Application No: BE/101/21/HH
Site Address: 3 Homing Gardens Bersted PO22 9AJ
Description of works: Replace metal framed/wood panel workshop in rear with brick-built workshop
(This application may affect the character and appearance of the North Bersted Conservation Area)

Thank you for your internet representation made on 15th November 2021 which has been recorded as an objection with the comments as follows:

extending homes Tel:- 01243 555208 enquiries@extendinghomes.co.uk	
TITLE:- Outbuilding @ 3 Haring Gardens North Bersted West Sussex PO22 9AJ	
DATE:-	2nd September 2021
SCALE:-	Elevations Scale 1-100 on A2 Paper
DRAWN:-	P.Robinson
DWG. No. 2021078/PL/2

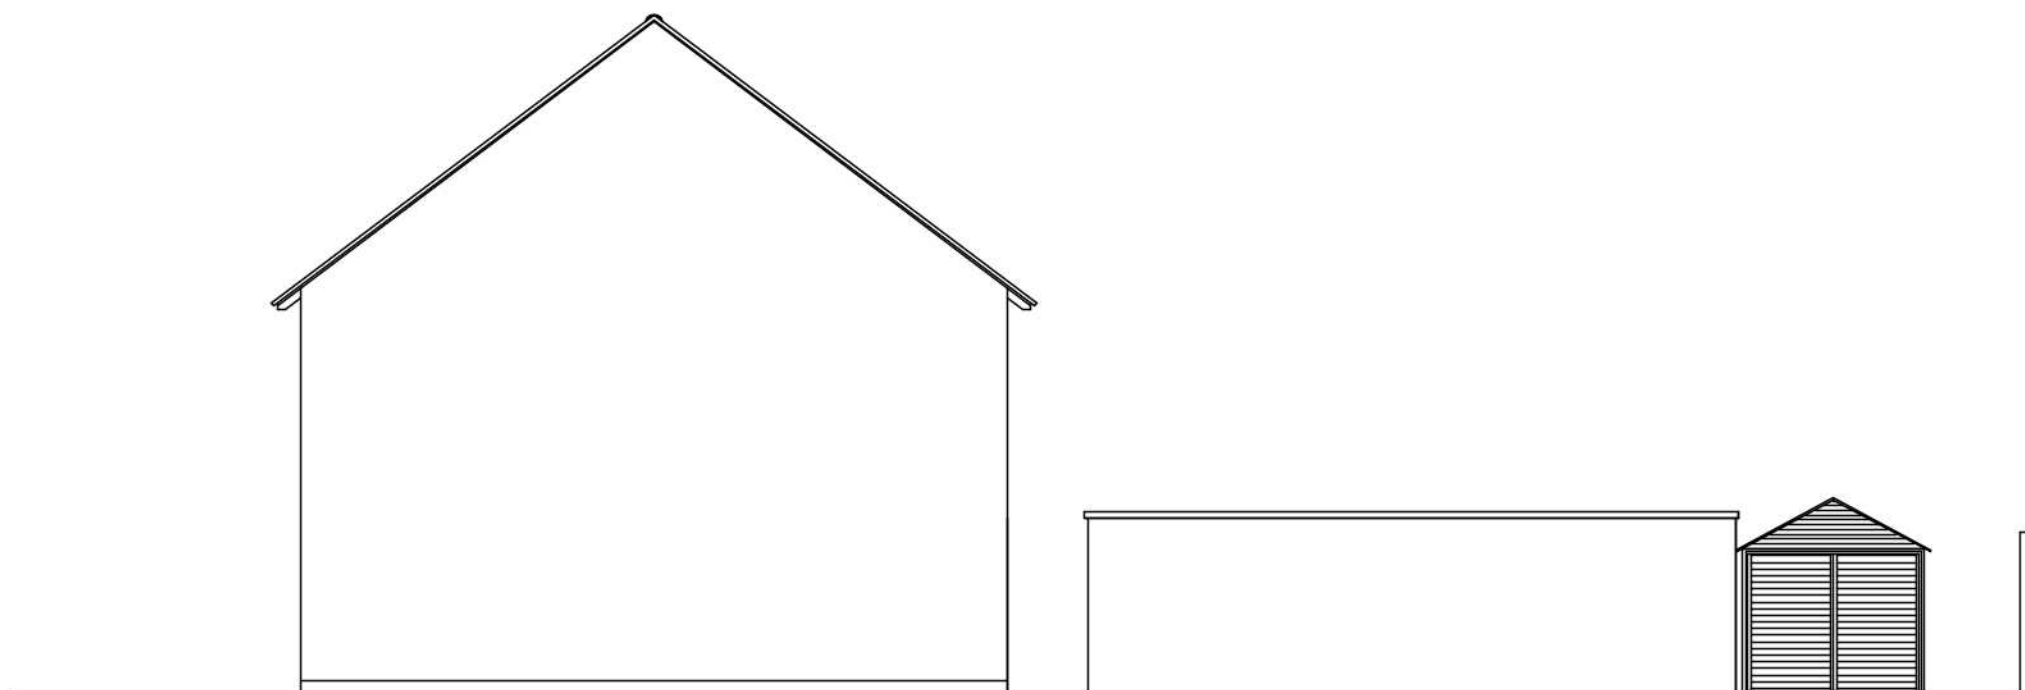
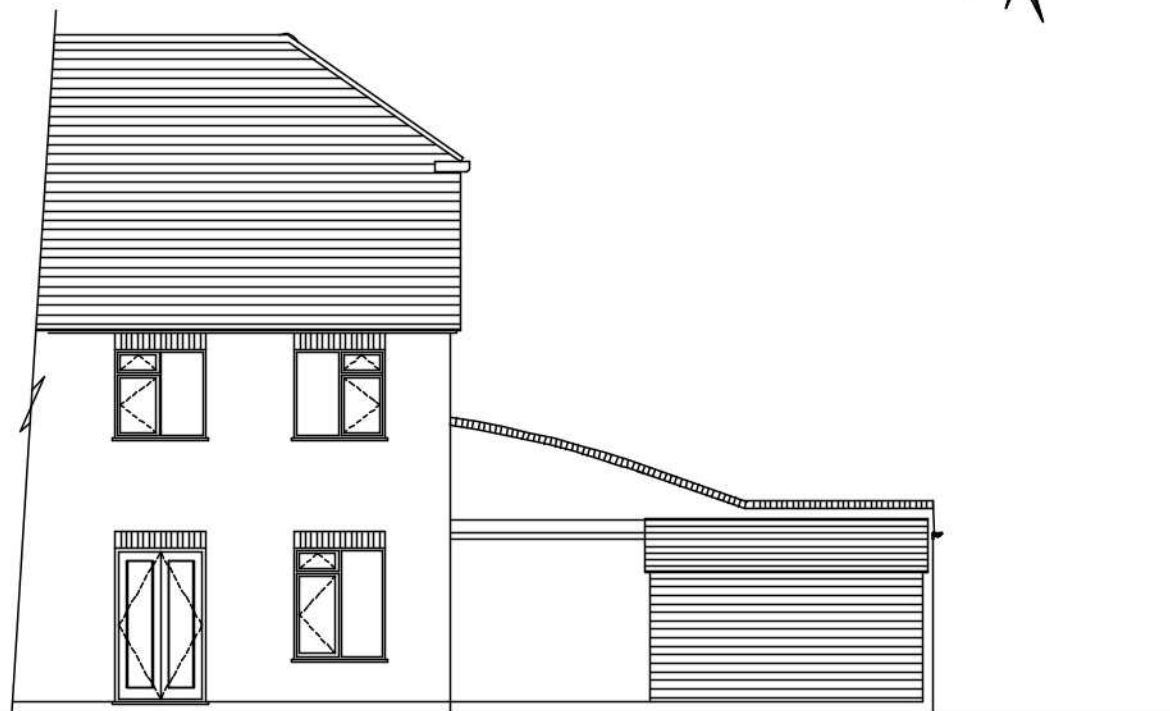
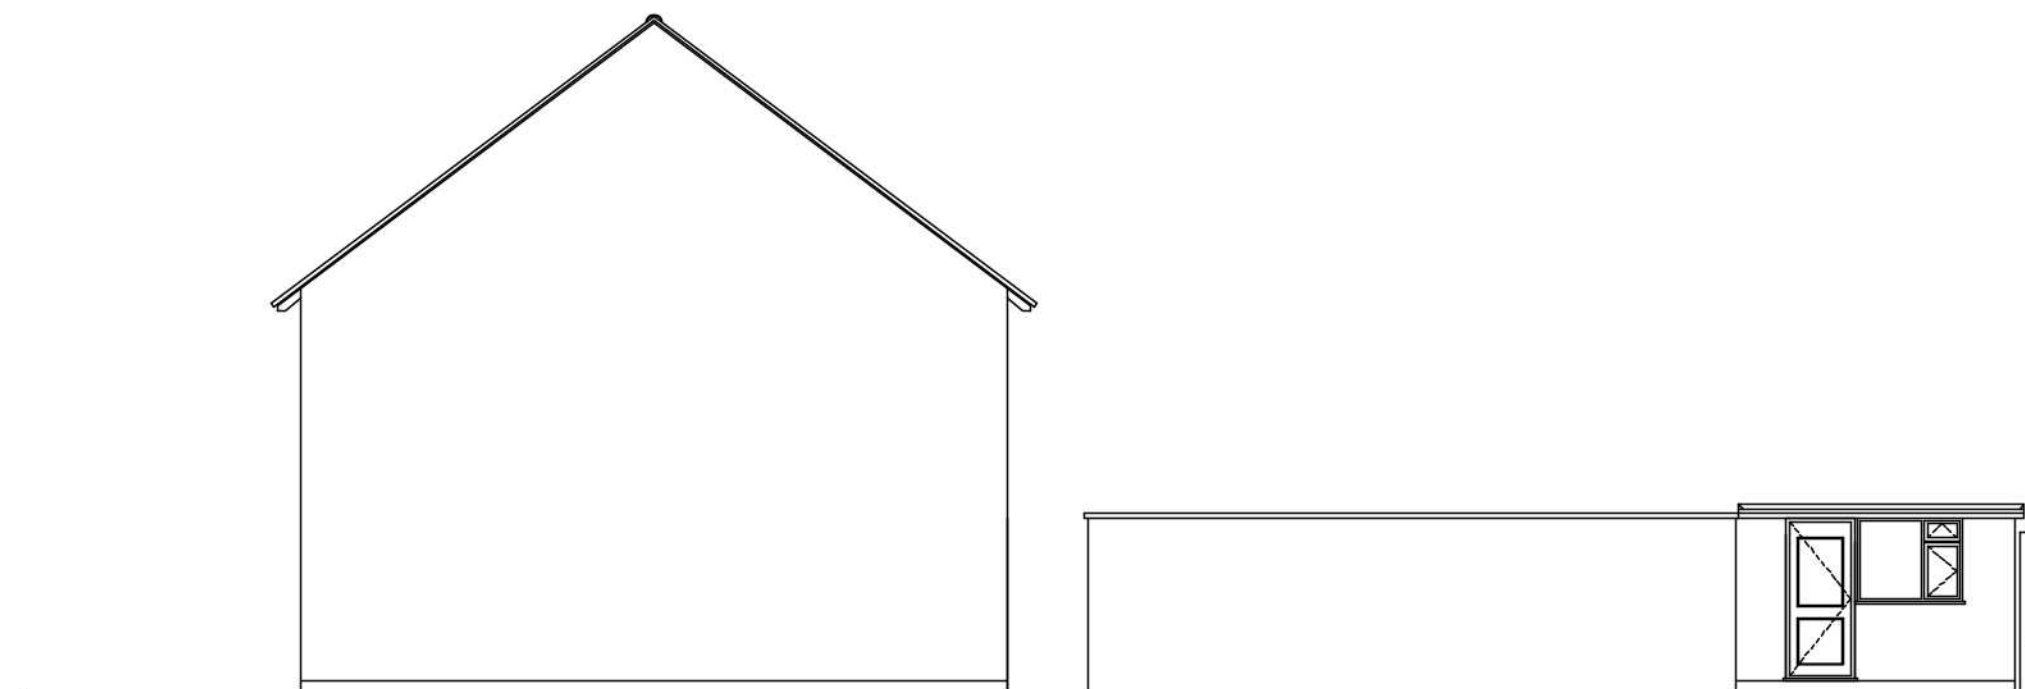
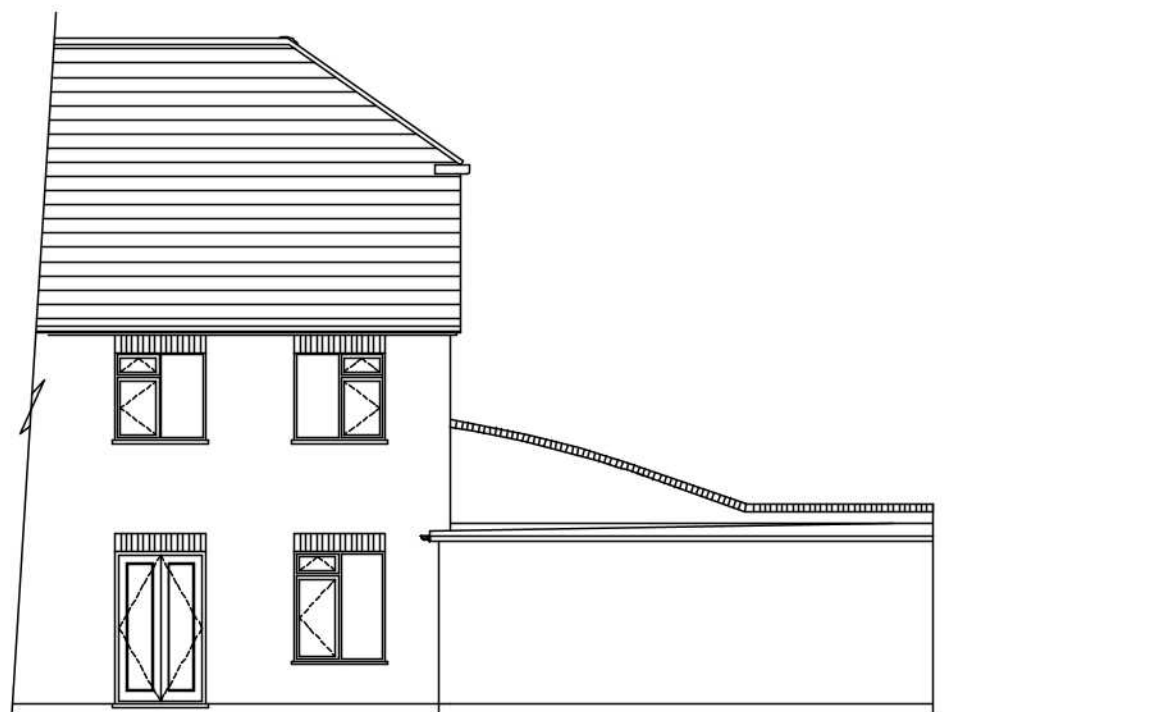
The plans show a very wide window facing into the shared compound causing concern regarding privacy and security.
